Online Comment

Application H04-0728-22
Location Land off Malting Lane Donington
Proposal Details of remediation method statement, surface water drainage scheme, construction and traffic management scheme, noise and vibration report, deposit of mud precautions, existing and proposed site levels/floor levels and foul water disposal (Conditions 8 (Part i), 9, 12, 14, 15, 16 and 18 of H04-0244-16)

Name Jeanette Reith
Address Environmental Protection - South Holland District Council

I have reviewed the Remedial Method Statement by Geo-Matters dated July 2022 and would like to make the following comments:

TITLE:
 Asbestos Delineation Plan

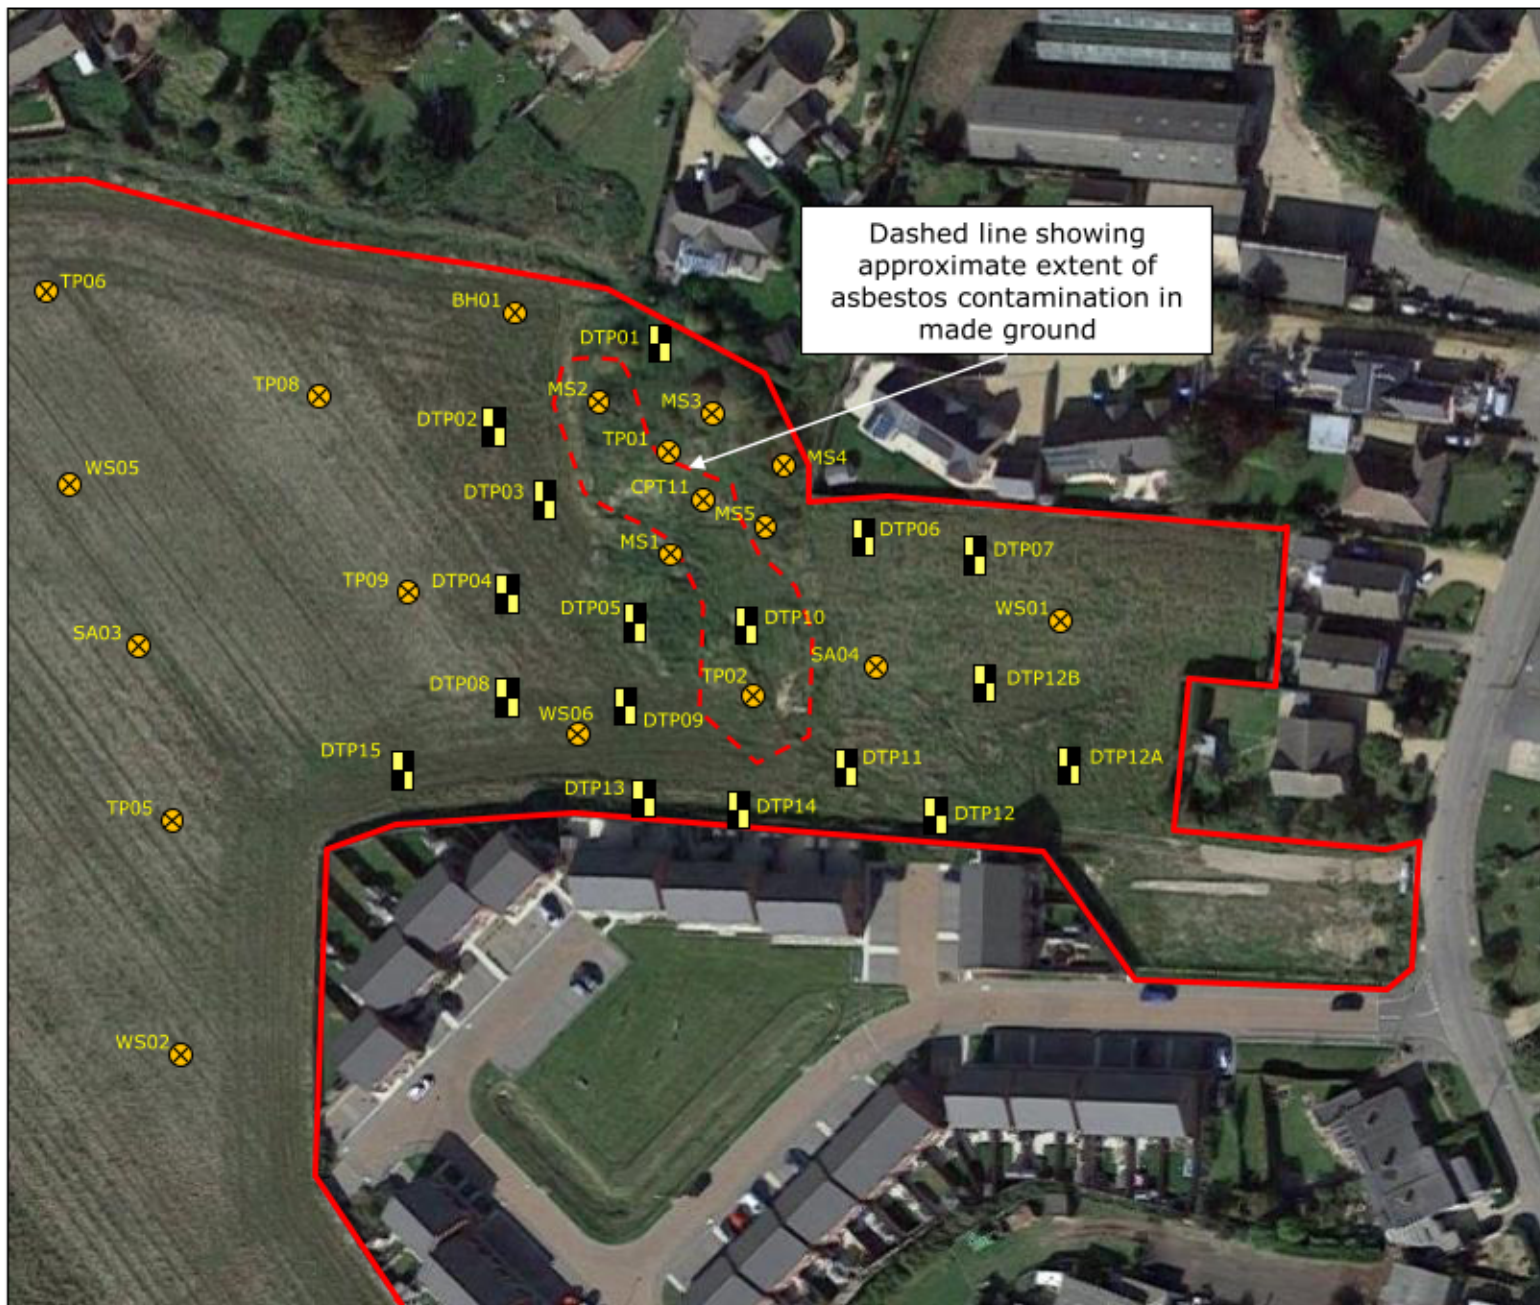
Further to my colleague, Sue Armour's comments of 01 November 2022, we still require clarification on the proposed remediation solution in the areas of asbestos and PAH contamination. The report proposes 'either capping or full removal of all contaminated soils' in these areas and we would like to know the chosen option moving forward. If the garden/landscaped areas are to be capped can the applicant please confirm whether a geotextile membrane will be used?
